**COMMENTARY
ABNORMALS**

WIGNAL'S GATE, HOLBEACH

CP VIABILITY

991-25

scale@A3	drawn	date	drawing number	revision
1:250	GW	MAY 25	1969-008	A

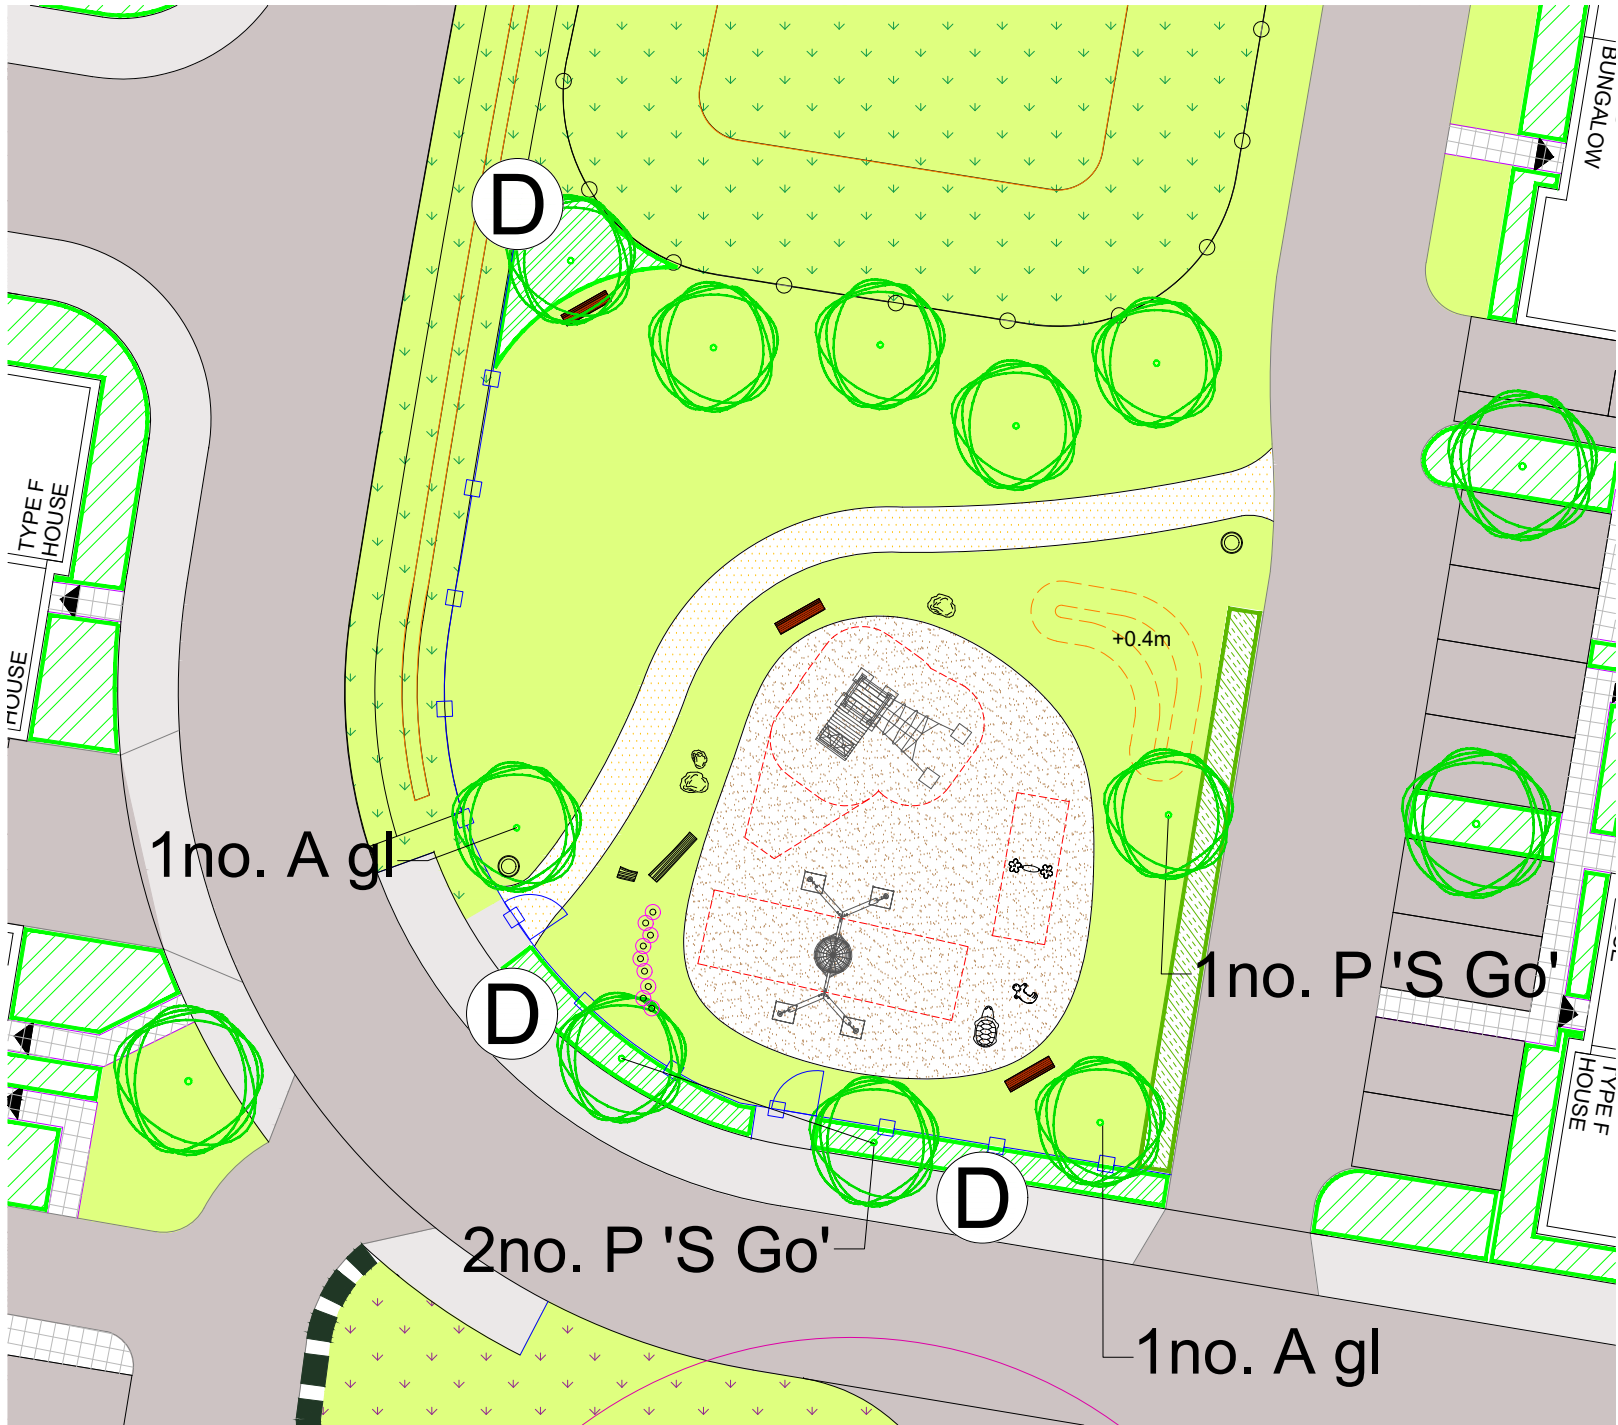
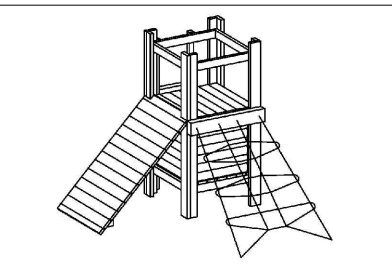
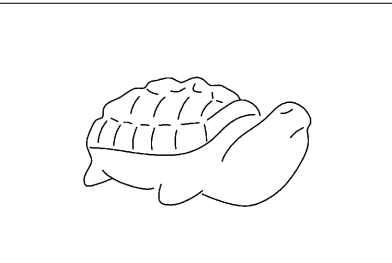
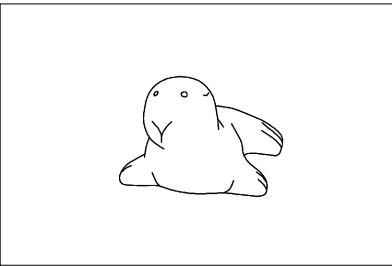
We note the inclusion of a LEAP in the approximate centre of the site, which is shown furnished with a timber climbing frame/rope structure, 2 Nr large stone animals, a cradle-nest swing and small individual step swing, benches and log seating, fencing & gate. We consider the lump sum £33k cost to be reasonable in covering the cost of forming the activity area shown on the drawings. However, we note that the provision of a LEAP is not an uncommon planning requirement and as such should not be deemed an abnormal provision for a scheme of this nature.
